File: SF18/26580  
Job ID: DOC18/168551  
Your Ref: SSD 8667

**RE: Heritage Division comments on exhibition of Goulburn Base Hospital Redevelopment (SSD 8667)**

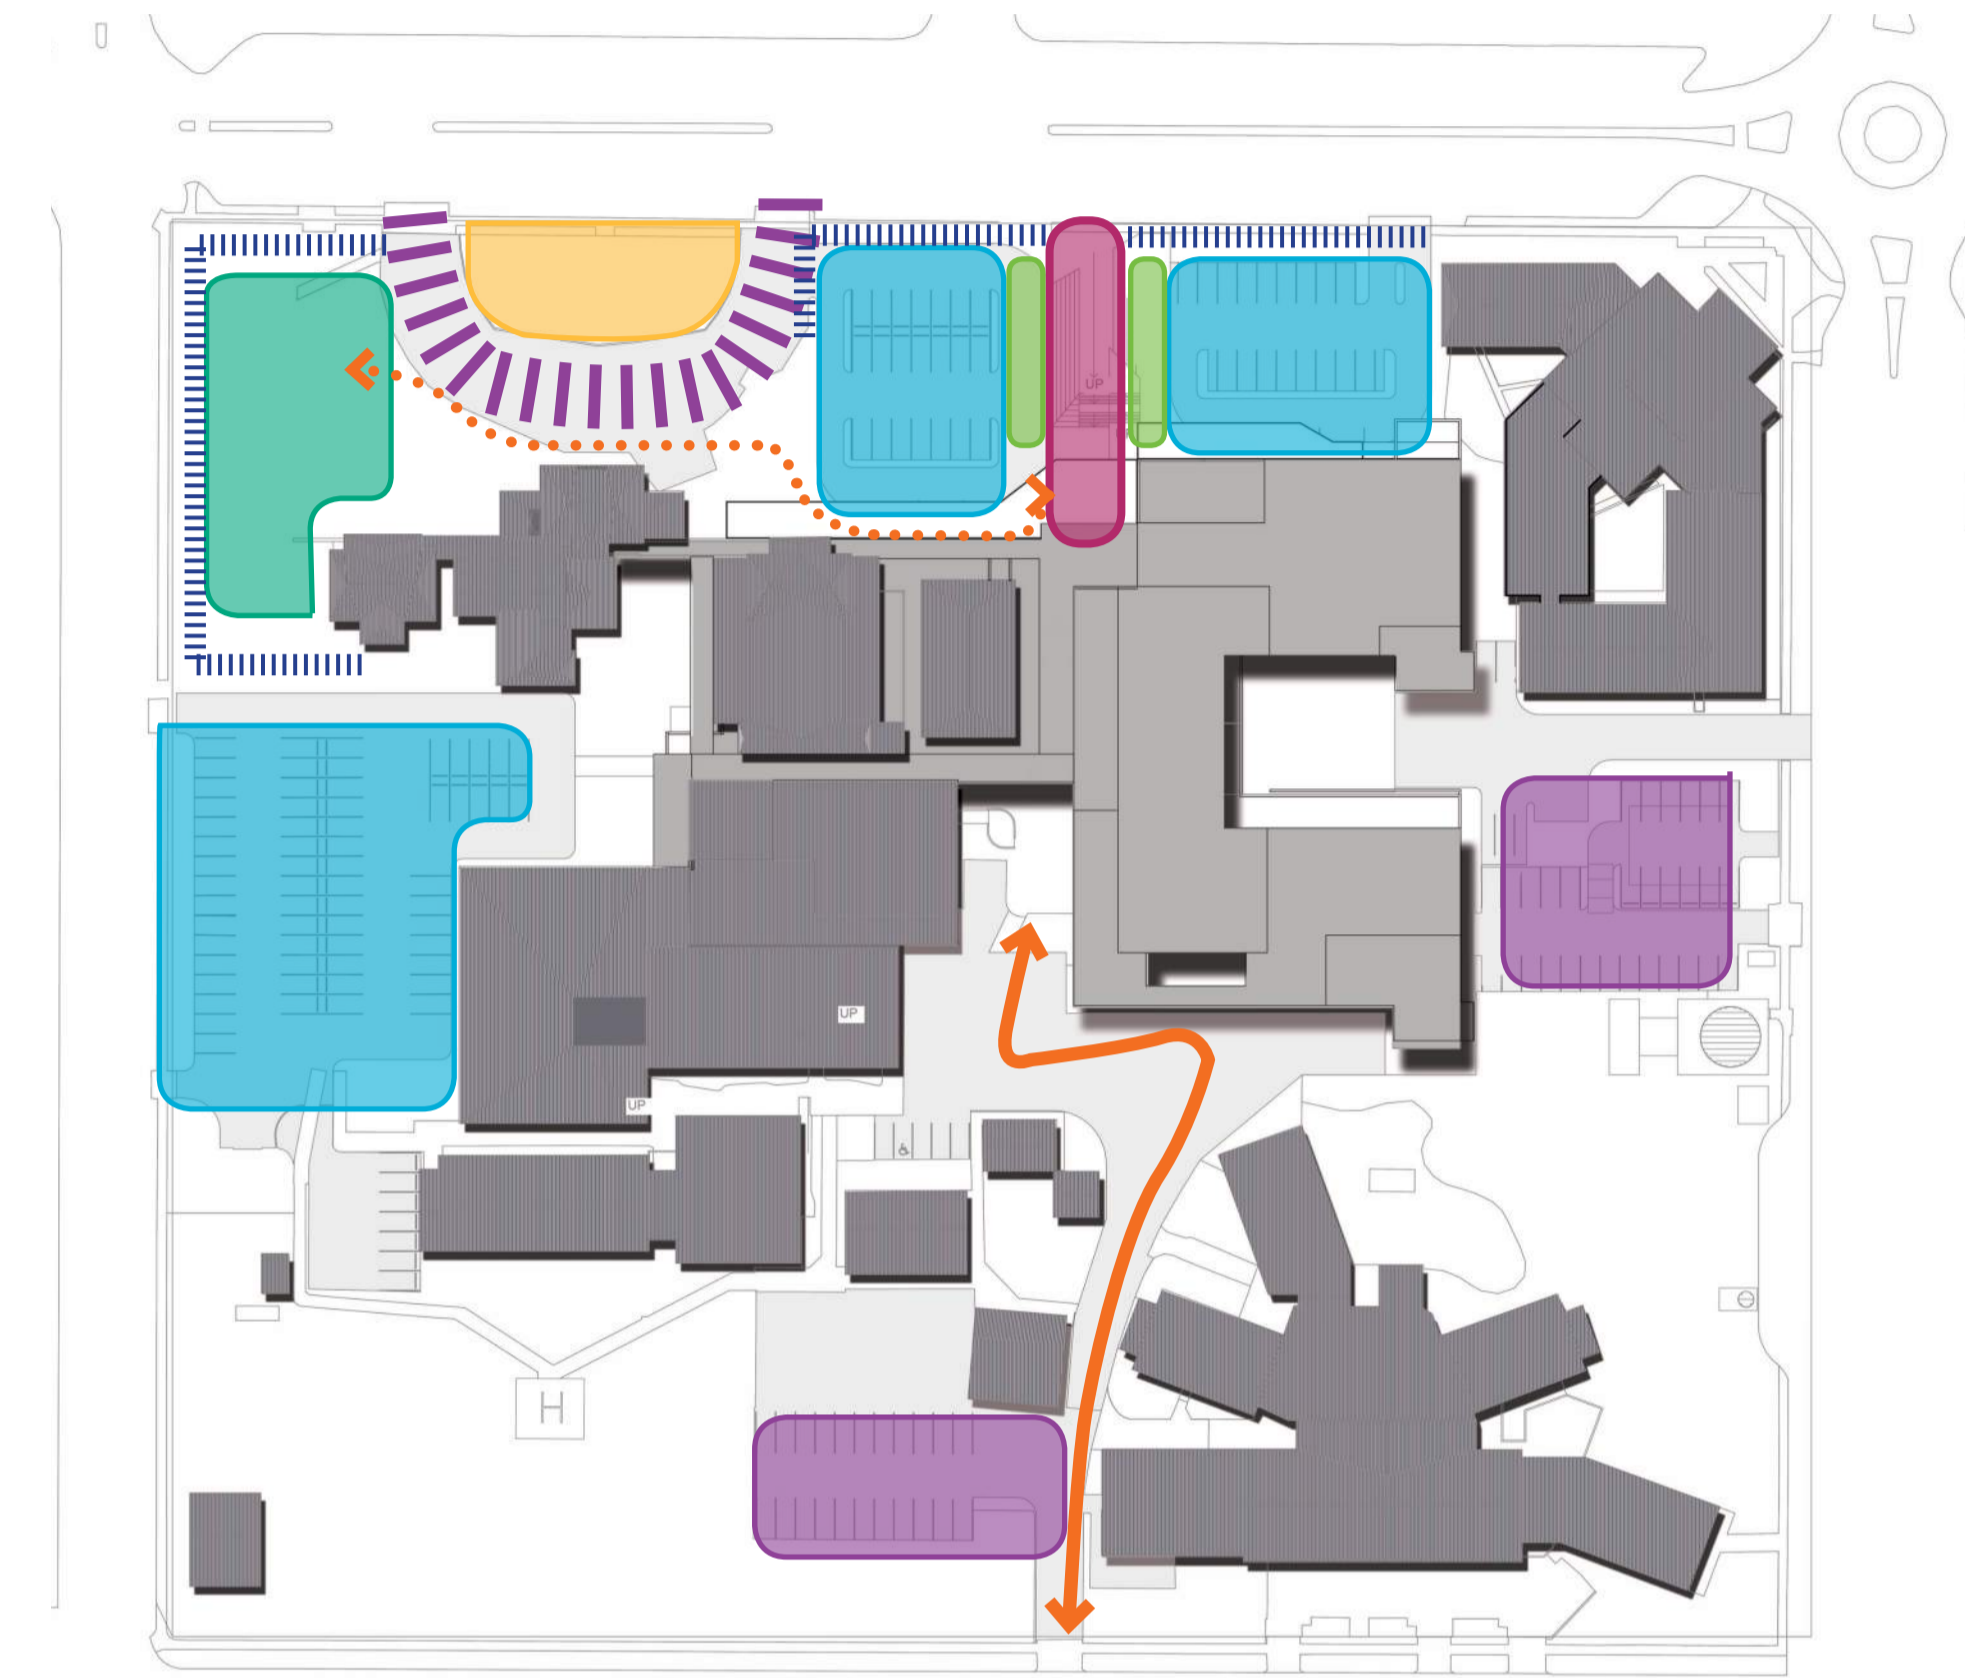
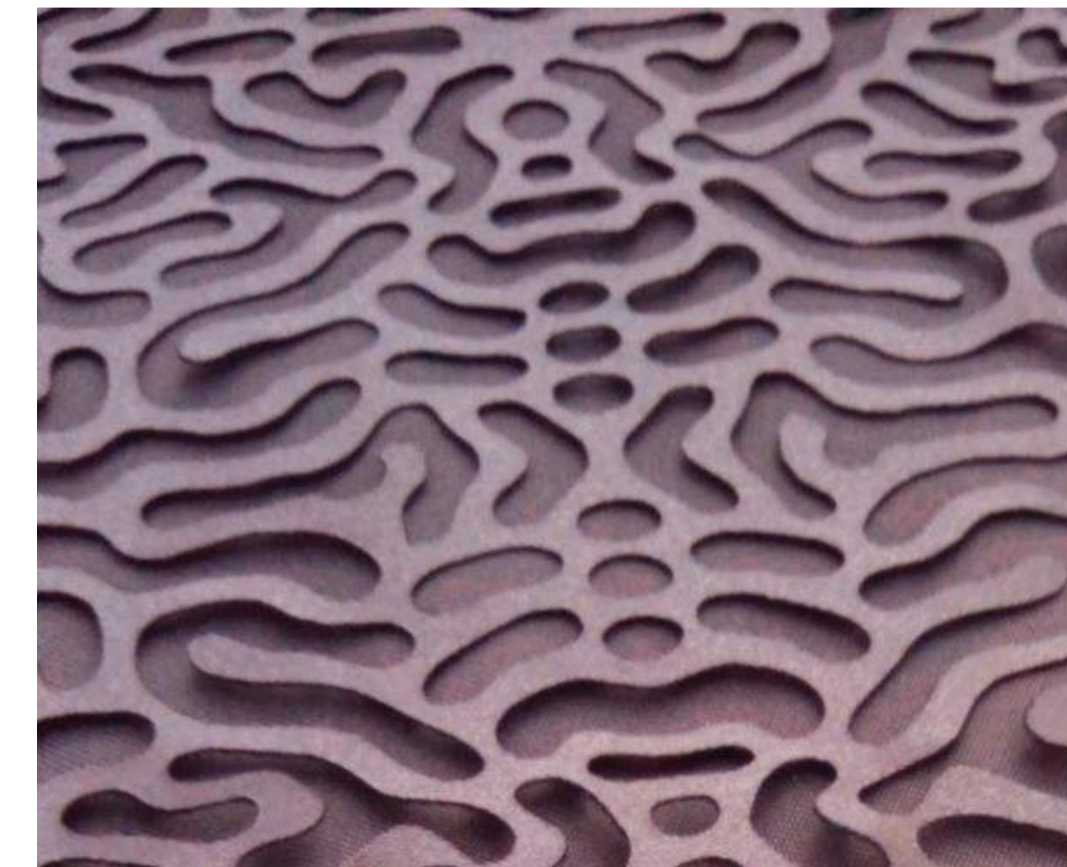
- The introduction of hardstand car parking into the Goldsmith Street setback in the location of the admissions building to be demolished would benefit from a landscape design aimed at softening this hardstand element to lessen the impact of the proposed car parking on the setting of the 1887 hospital building.
